East Yorkshire Solar Farm Nationally Significant Infrastructure
Project

Registration Comments

March 2024

AECOM

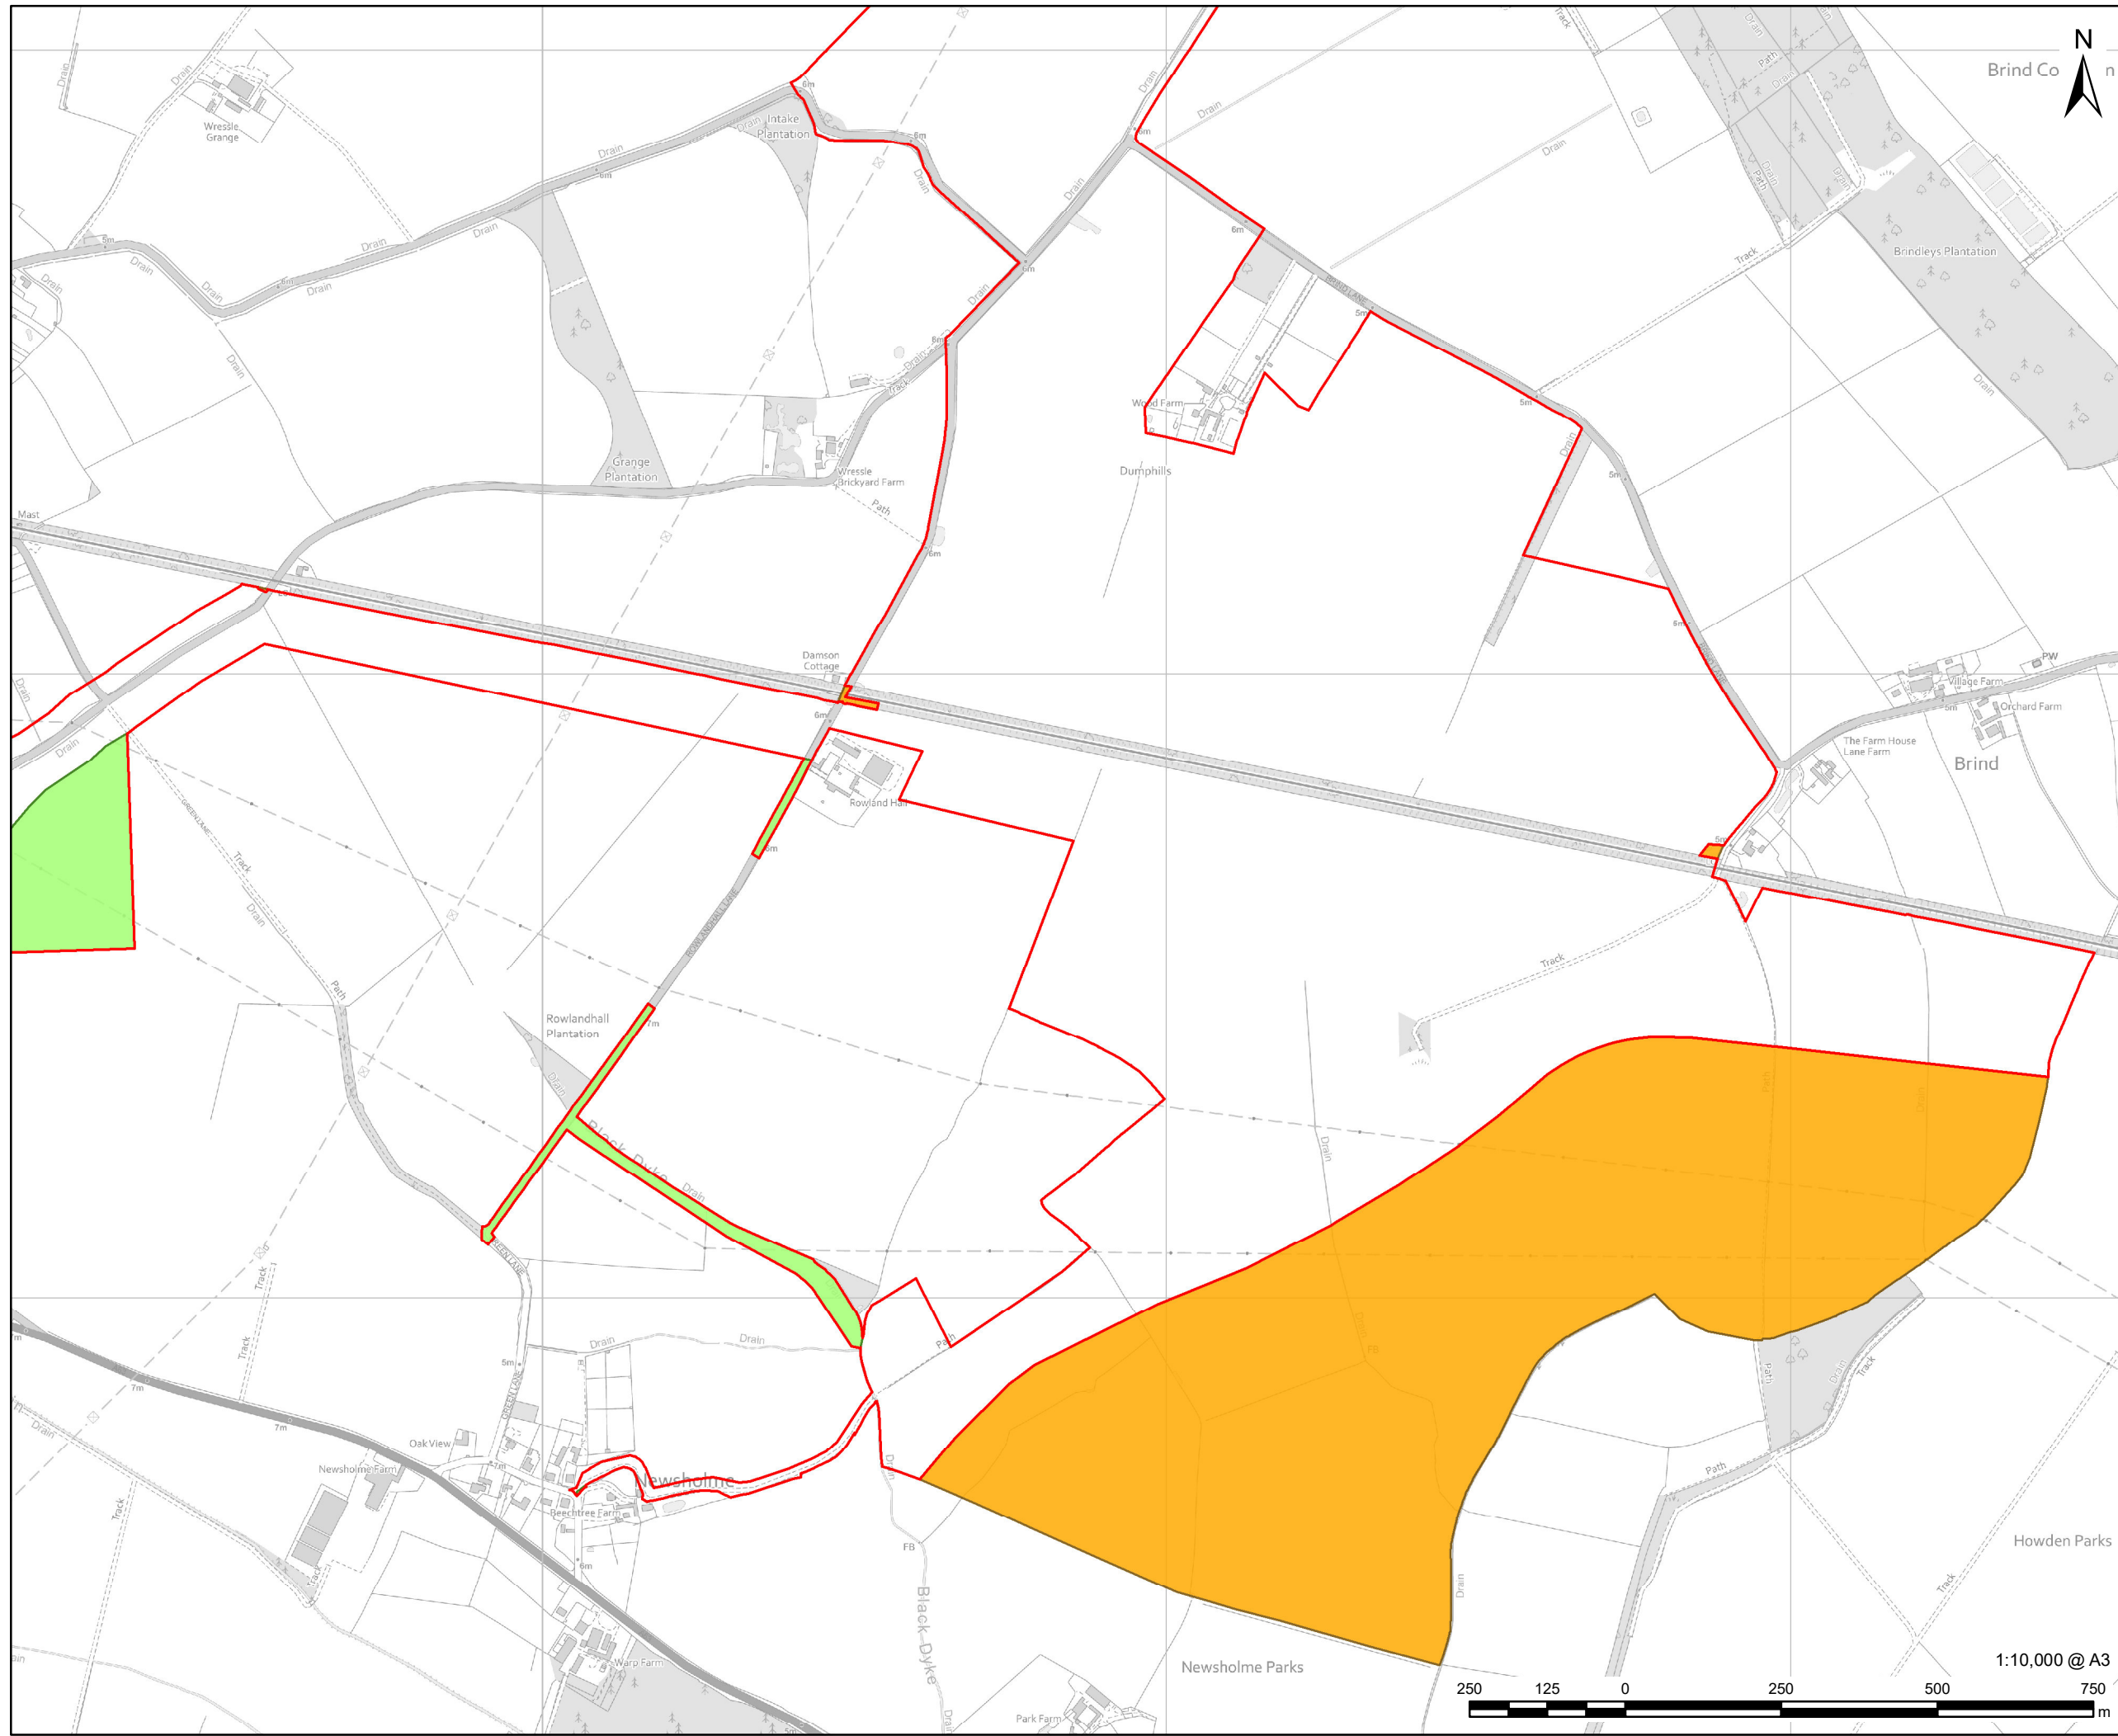
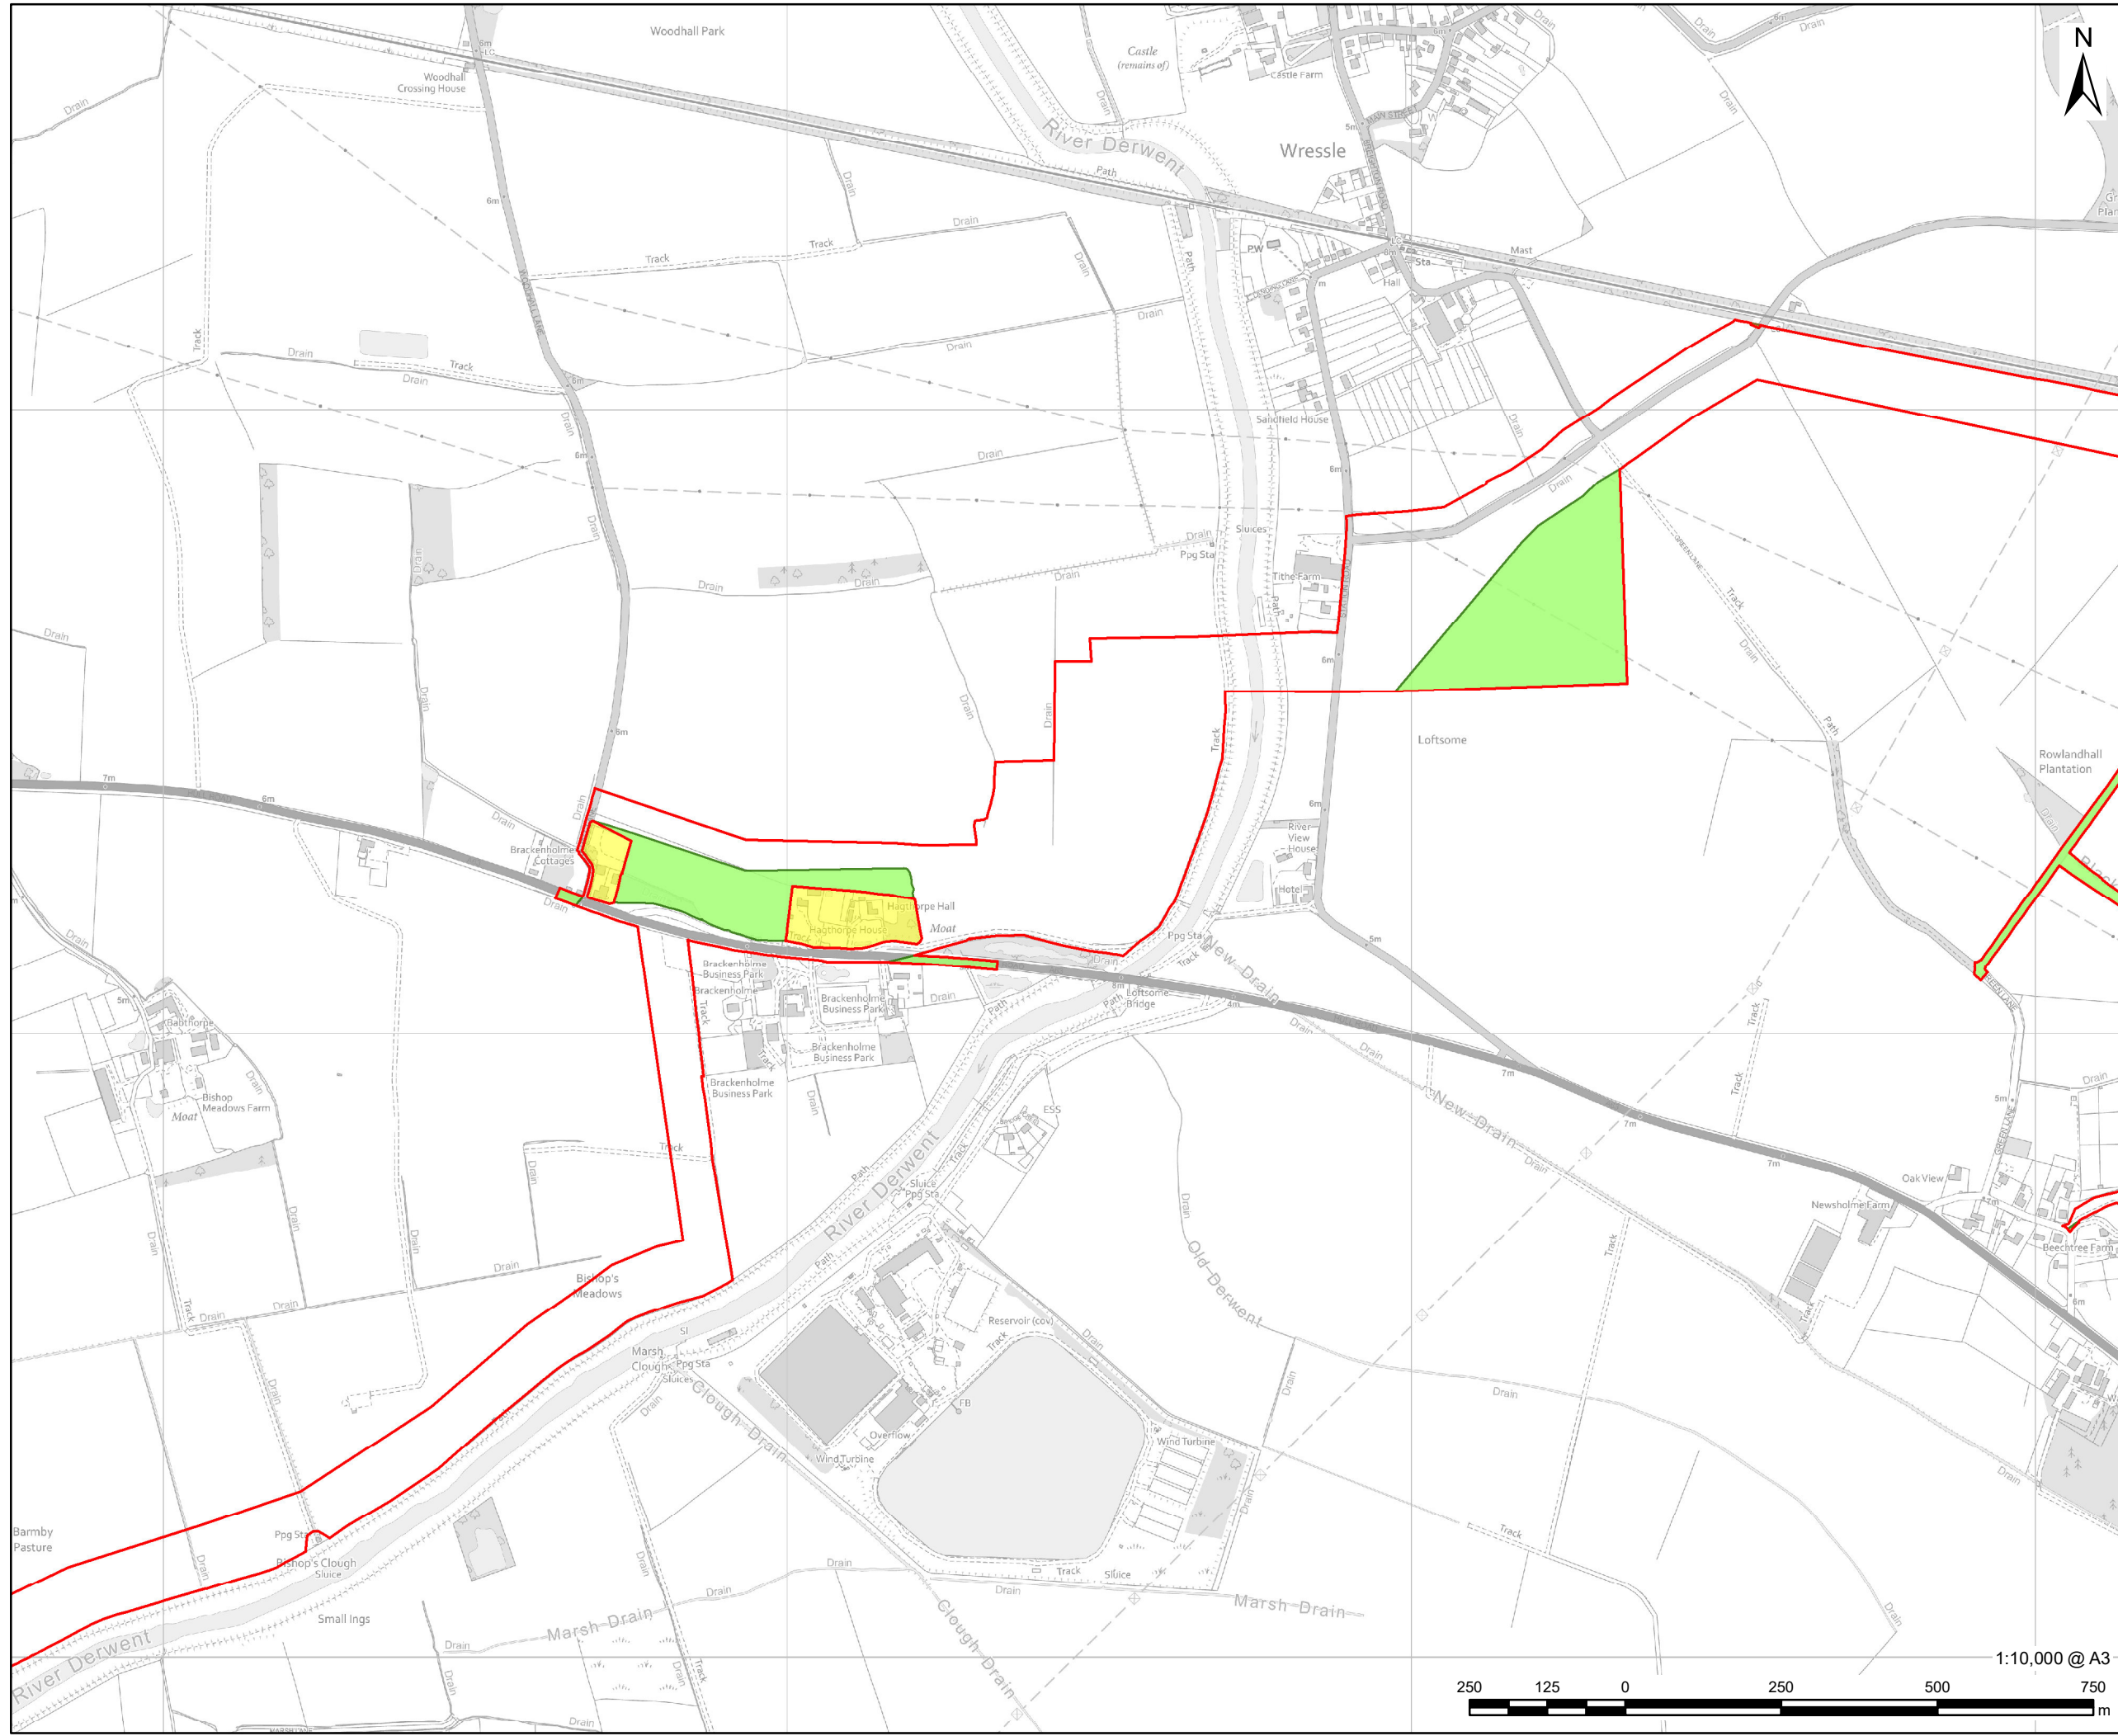
- 2.4. Contrary to this guidance it appears that the applicant has not addressed site-specific issues in relation to our client's property, nor indeed wider issues in relation to impacts on landscape and public rights of way. This is noted from a comparison of the early engagement illustrative plans and the submitted proposal (see **Appendix 1** of this representation). Despite our client writing to the applicant on numerous occasions to raise their concerns, the layout surrounding our client's property has not changed substantially. The same planting scheme appears to have been retained at the north of area 2f and the volume of panels increased in area 2e.

Streets Rights of Way and Access Plan Sheet 14 of 22

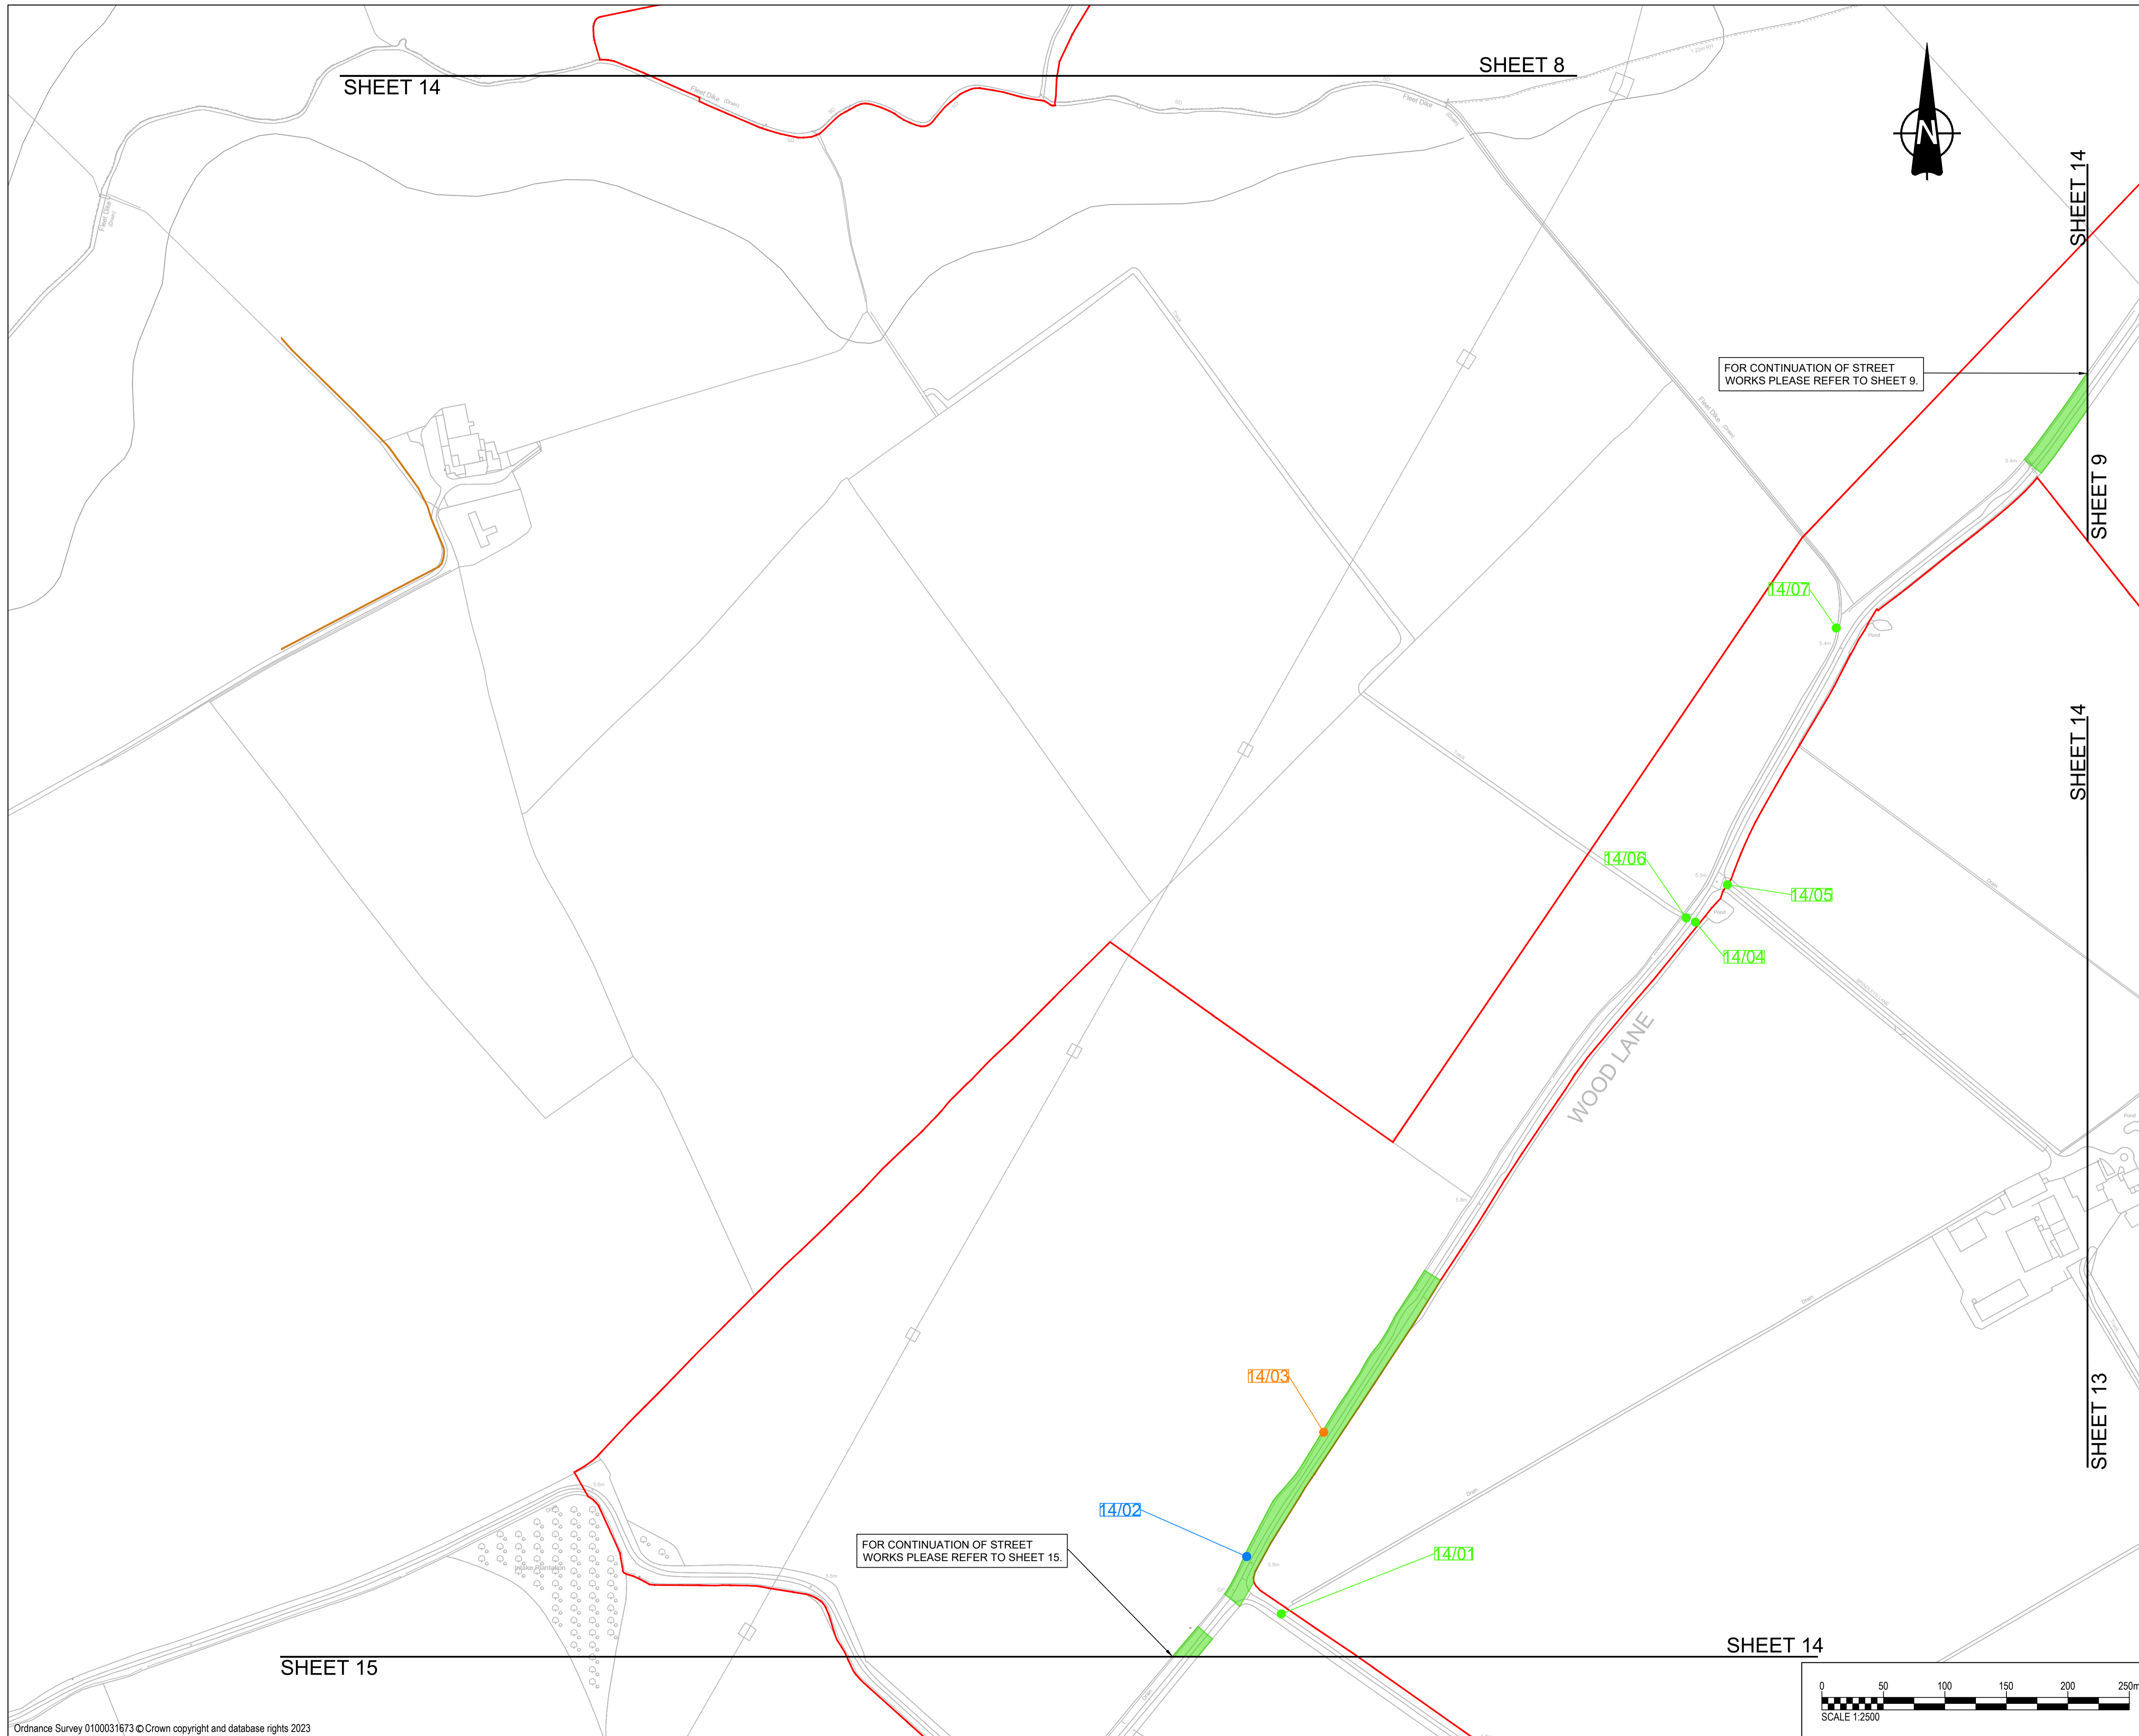
- 4.5. The application proposes a partial diversion of the PRow to the north east of our client’s property (PRow 10/04 – PRow 10/05). It is not clear from the submitted plans however, the diversion corridor appears to propose to divert the PRow into the parcel 2e. The enjoyment of this PRow will be significantly impacted due to the change in character of part of the PRow into a field of built form in the way of solar panels.
